**EL PASO COUNTY PLANNING AND  
 COMMUNITY DEVELOPMENT  
 DEPARTMENT**

**SITE DEVELOPMENT PLAN CHECKLIST**

Site Development Plan		Applicant	PCD
<p>In order to establish a use or obtain a building permit, in most cases, the LDC requires Site Development Plan Review for more complex uses (most often including multi-family, commercial, and industrial uses) to determine conformance of the proposed use(s) or structure(s) with the provisions of the LDC, ECM, or any other applicable regulations or any specific land use approvals or permits, and other rules, regulations, codes and ordinances administered by the PCD. Specifically, many of the requirements for approval of a site development plan can be found in Chapter 6 of the LDC. The use tables in Chapter 5 of the LDC (Table 5-1 and 5-2) identify when the applicant shall submit a Site Development Plan and when a PCD planner and engineer shall review a Site Development Plan to establish a use or to construct a structure. Site Development Plans are approved administratively by the PCD Director, unless otherwise modified by a condition of approval.</p>

1 Coniferous Tree Planting Detail NOT TO SCALE

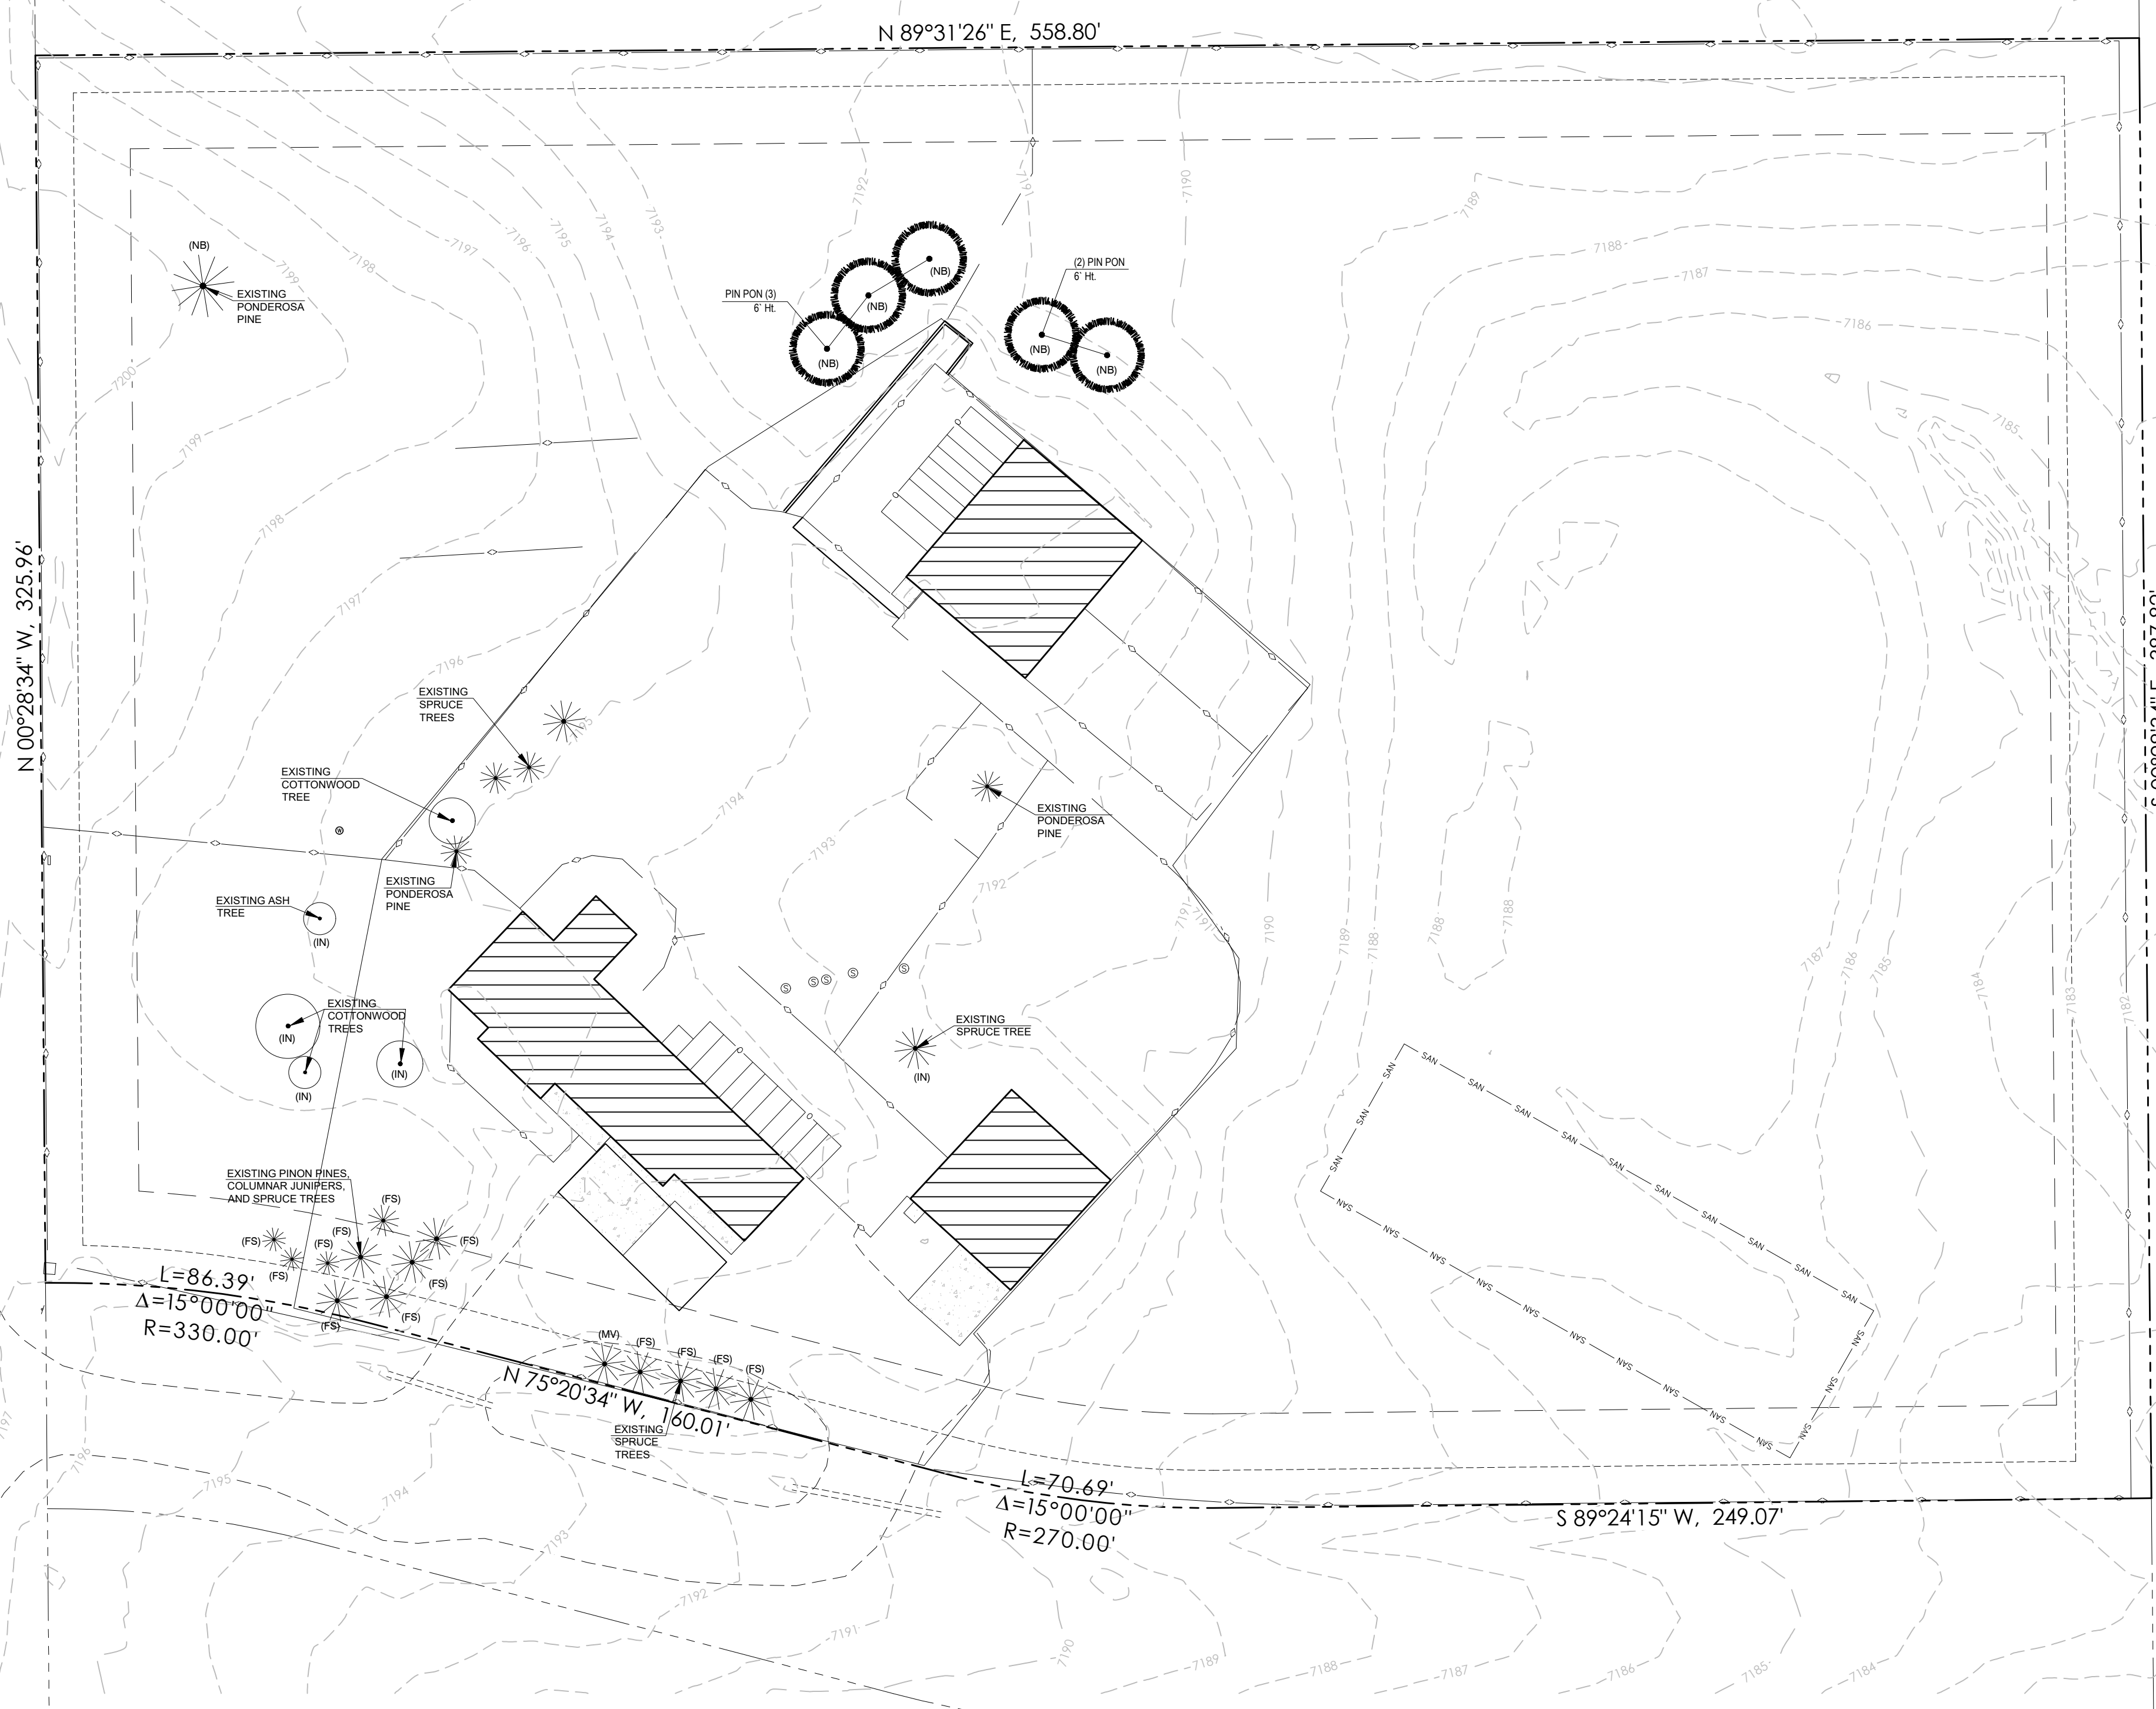
<b>Site Plan Drawing to include the following elements:</b>			
1	Date, north arrow, and a graphic scale		✓
2	Vicinity map showing the subdivision in relation to section lines and existing or proposed arterial or collector roadways.		✓
3	Location and dimension of the all property lines, rights-of-way, and all existing and proposed easements		✓
4	Signature block for the Planning and Community Development Director a minimum of 1 inch by 2 inches	x	
5	The footprint of all existing and proposed buildings and the setback distances from each existing and proposed structure to the property lines		✓
6	Location of all sidewalks, trails, fences and walls, retaining walls, or berms	x	
7	Location and dimensions of all existing and proposed signage on site <span style="background-color: #e0ffe0;">Any proposed signs?</span>	x	
8	Traffic circulation on site including all points of ingress/egress into the property	x

9	The layout and location of all off-street parking, loading and other vehicular use areas, unless otherwise depicted in detail on a separate parking plan. If depicted on a separate parking plan then depiction of the parking areas are required.	x

10	The layout and location of all landscaping, including landscape setbacks, unless otherwise depicted in detail on a separate landscape plan. If depicted on a separate landscape plan then depiction of the landscape areas are required.		✓
11	Location of all ADA spaces, ramps and signs, including ADA pathways	X	
12	Location of existing and proposed water and wastewater infrastructure, including well and septic locations, if applicable		✓
13	Location of all no-build areas, floodplain, drainageways and facilities	X	
14	Location of all garbage receptacles with a graphical depiction of the screening mechanism	X	
15	Location of all existing and proposed utility lines and associated infrastructure	X	
16	Any additional information required pursuant to any associated conditions of approval or plat notes.		
17	Any other additional items as required by the PCD Director deemed necessary to address the applicable review criteria:
